20th April 2012

Application for Planning Permission

Development Extension to agriculture building
Location Sefter Farm Pagham Road Pagham

PROPOSED PHASE 2
Location Plan
April 2012
4311-P-200
1:2500@A3

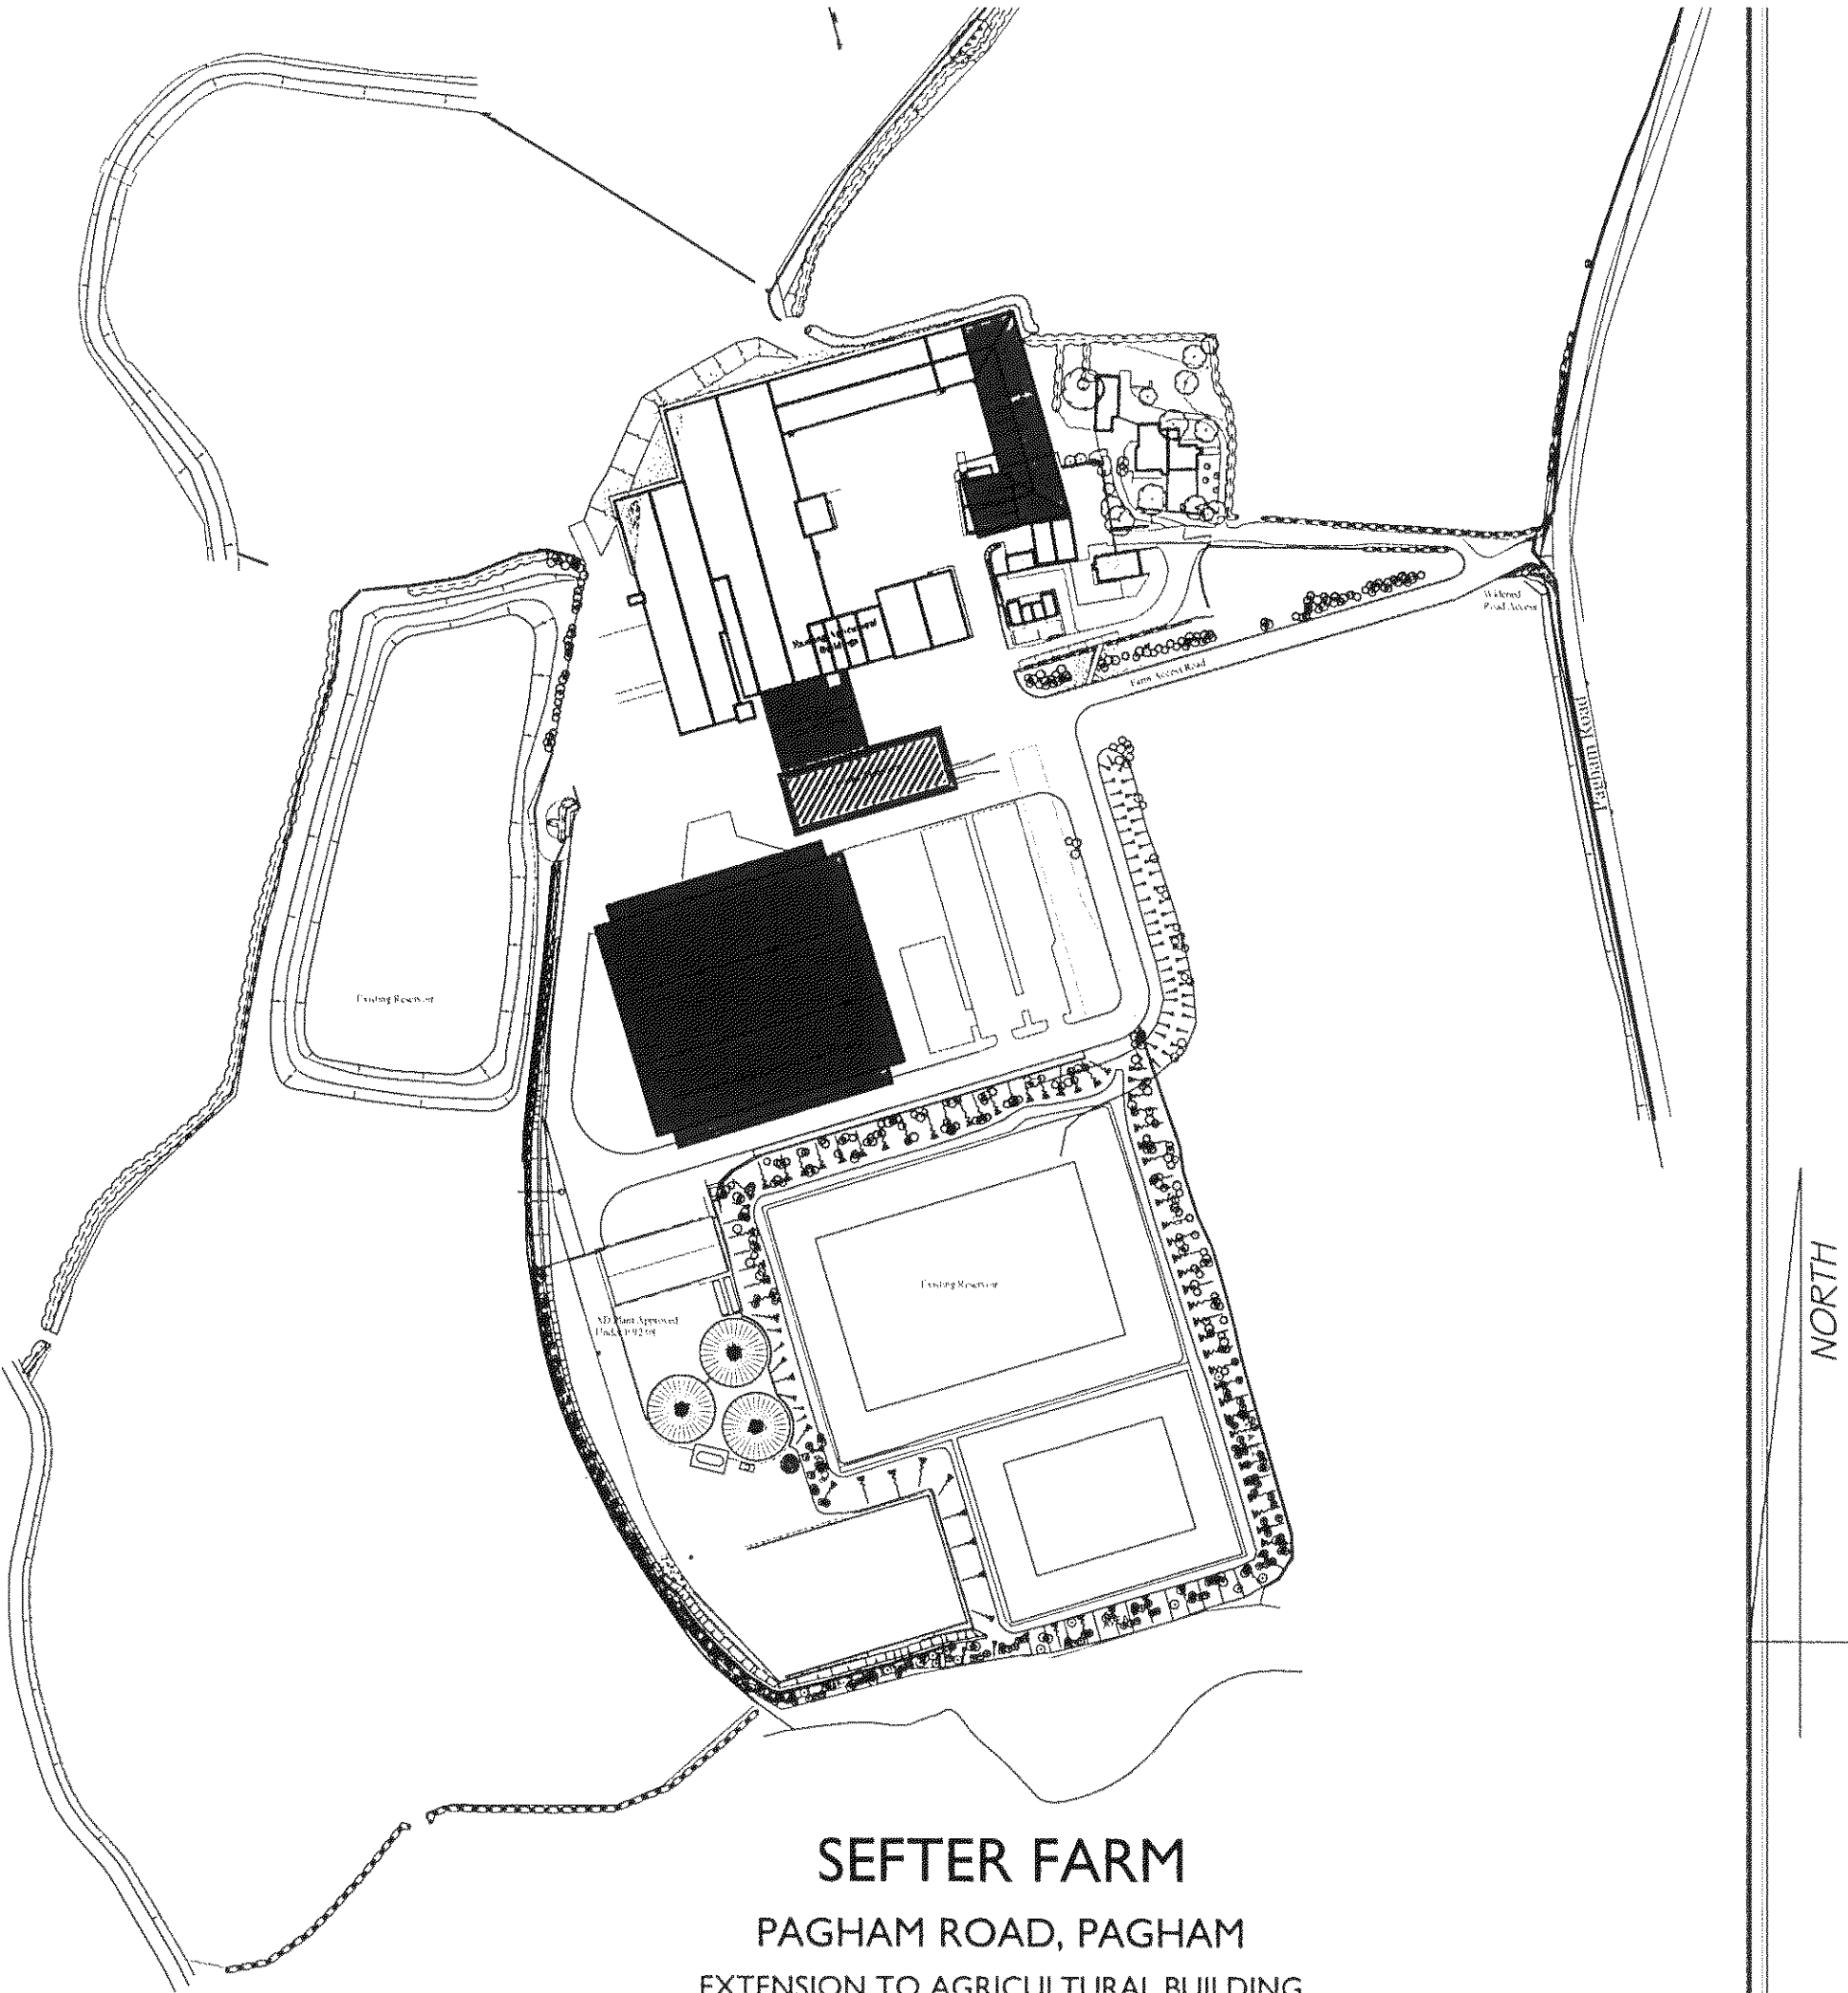
I require 1 electronic or 3 paper copies of a revised location plan showing any other land owned by the applicant edged in blue, in accordance with the guidance notes available on our website detailed below (click on National List).

PROPOSED PHASE 2
Block Plan
April 2012
4311-P-201
1:1000@A3

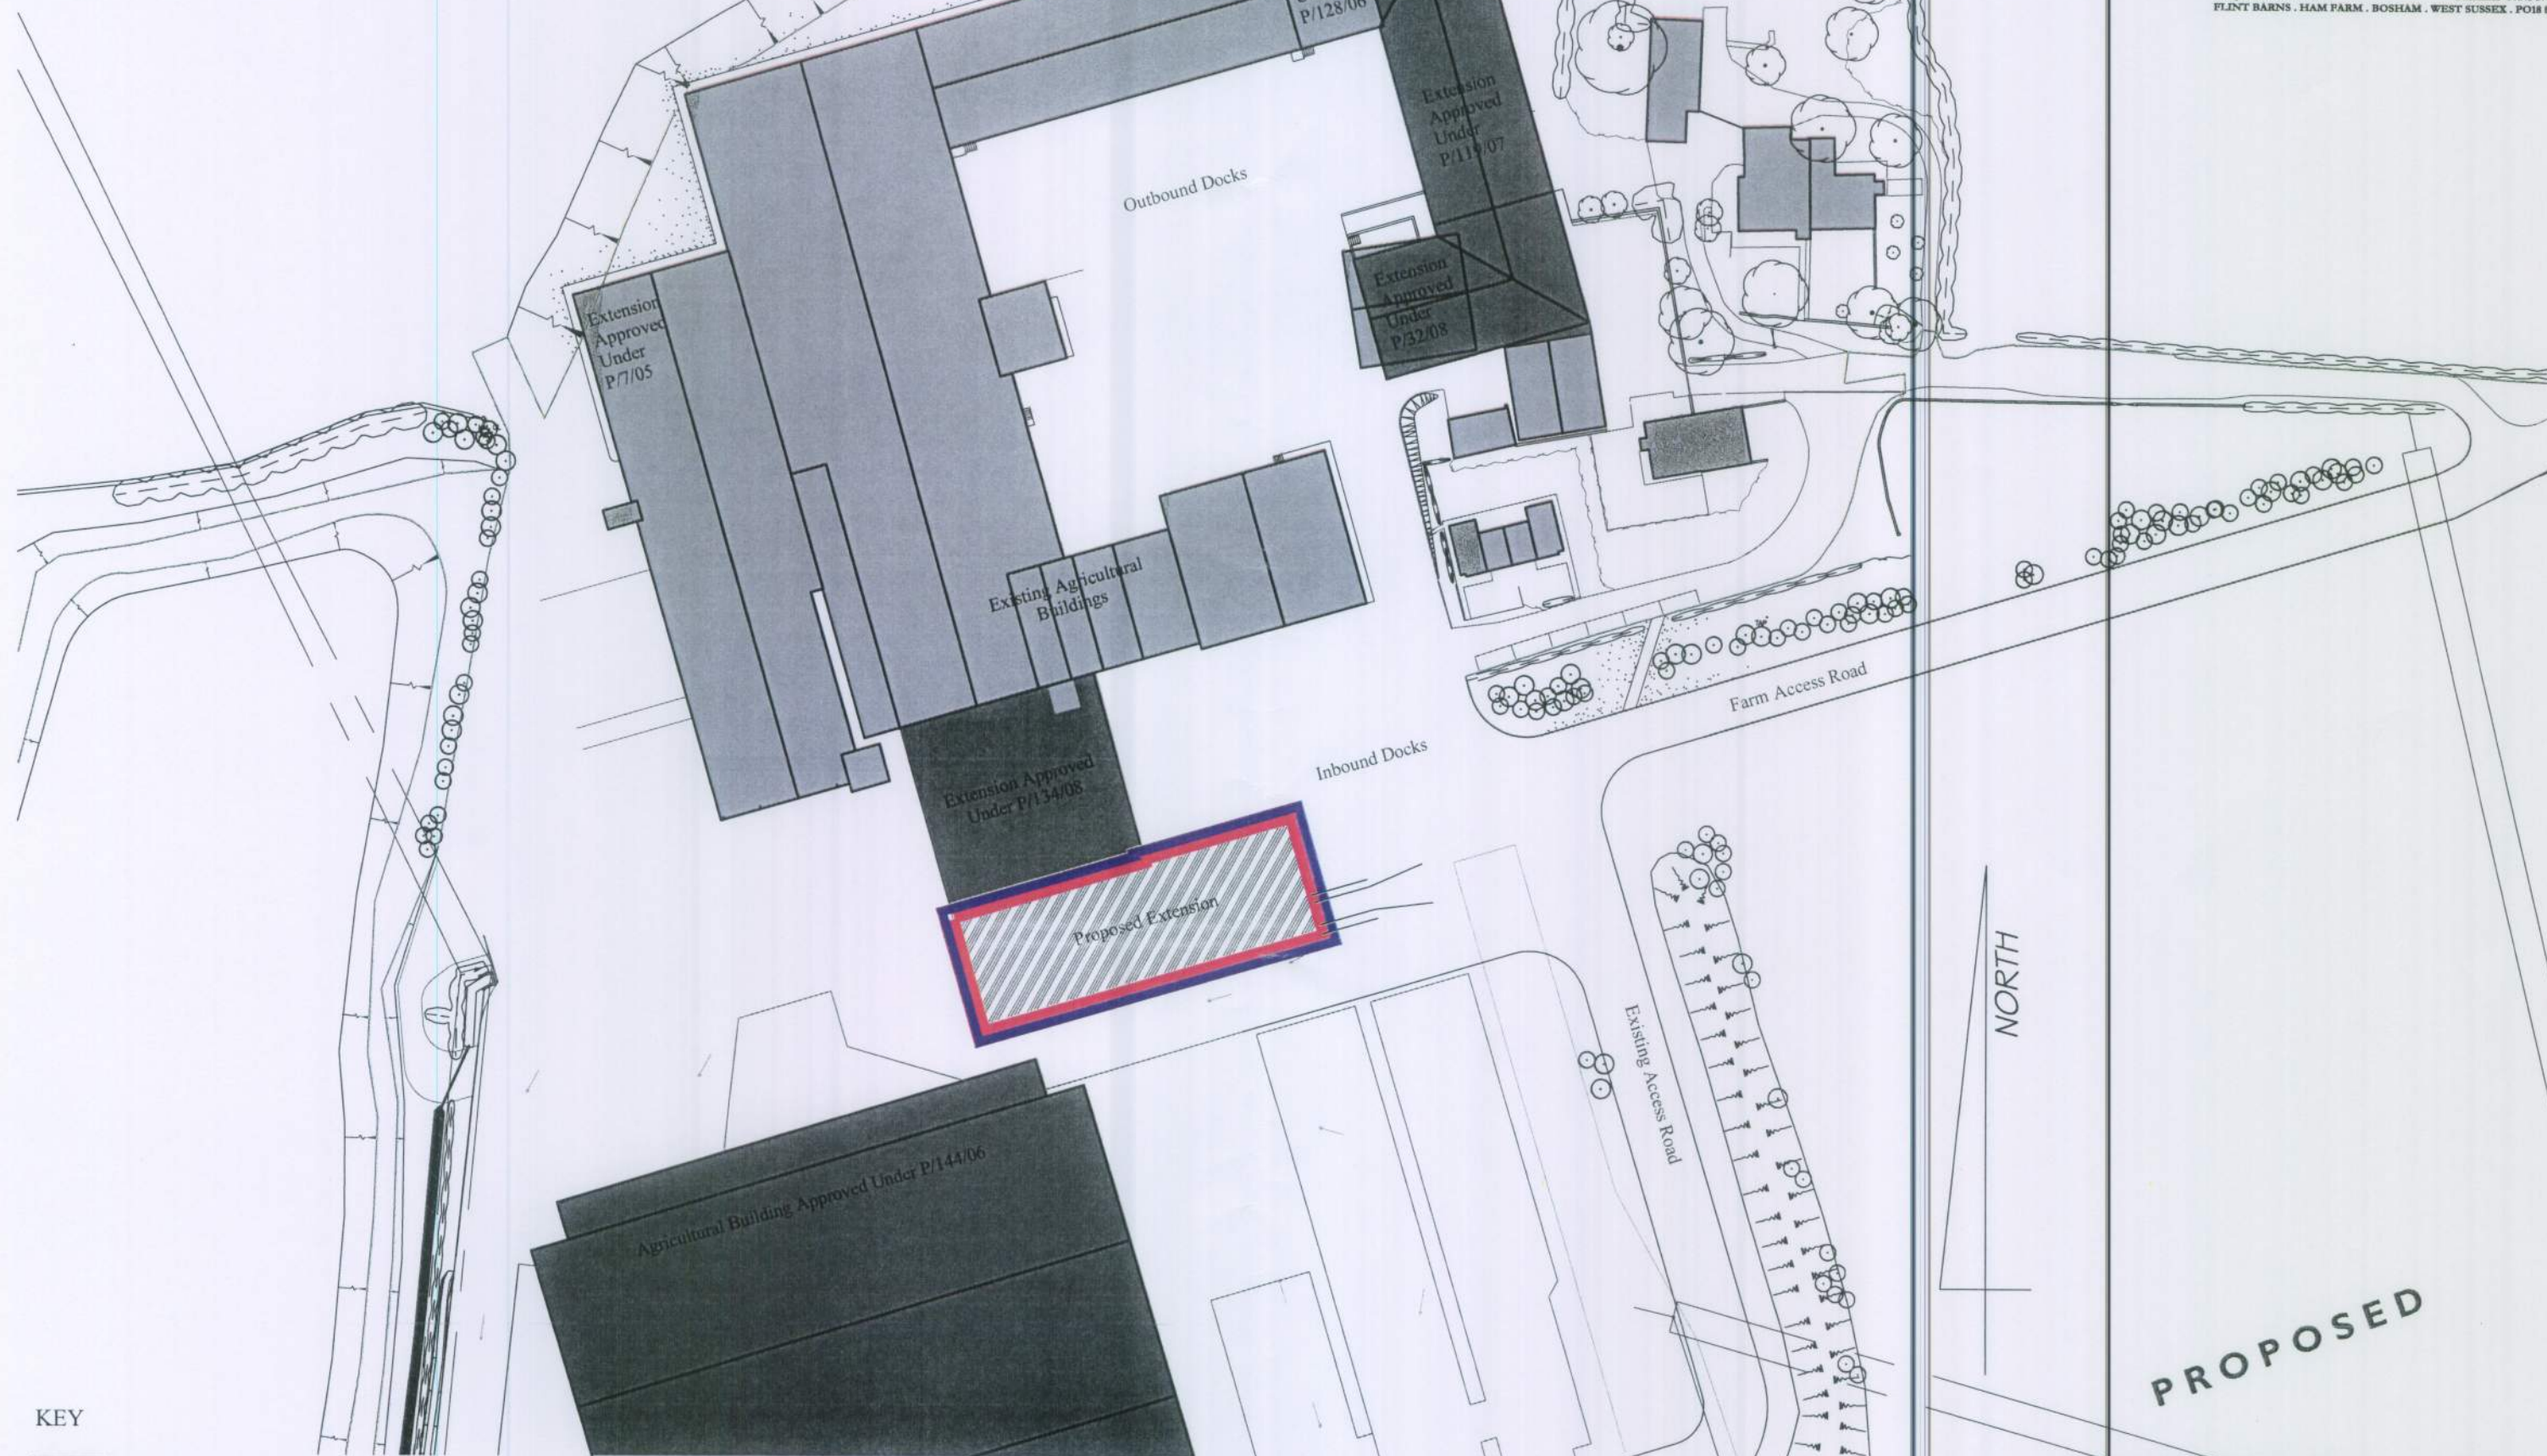
I require 1 electronic or 3 paper copies of a revised block plan showing a blue edge around any other land owned by the applicant, in accordance with the guidance notes available on our website detailed below (click on National List).
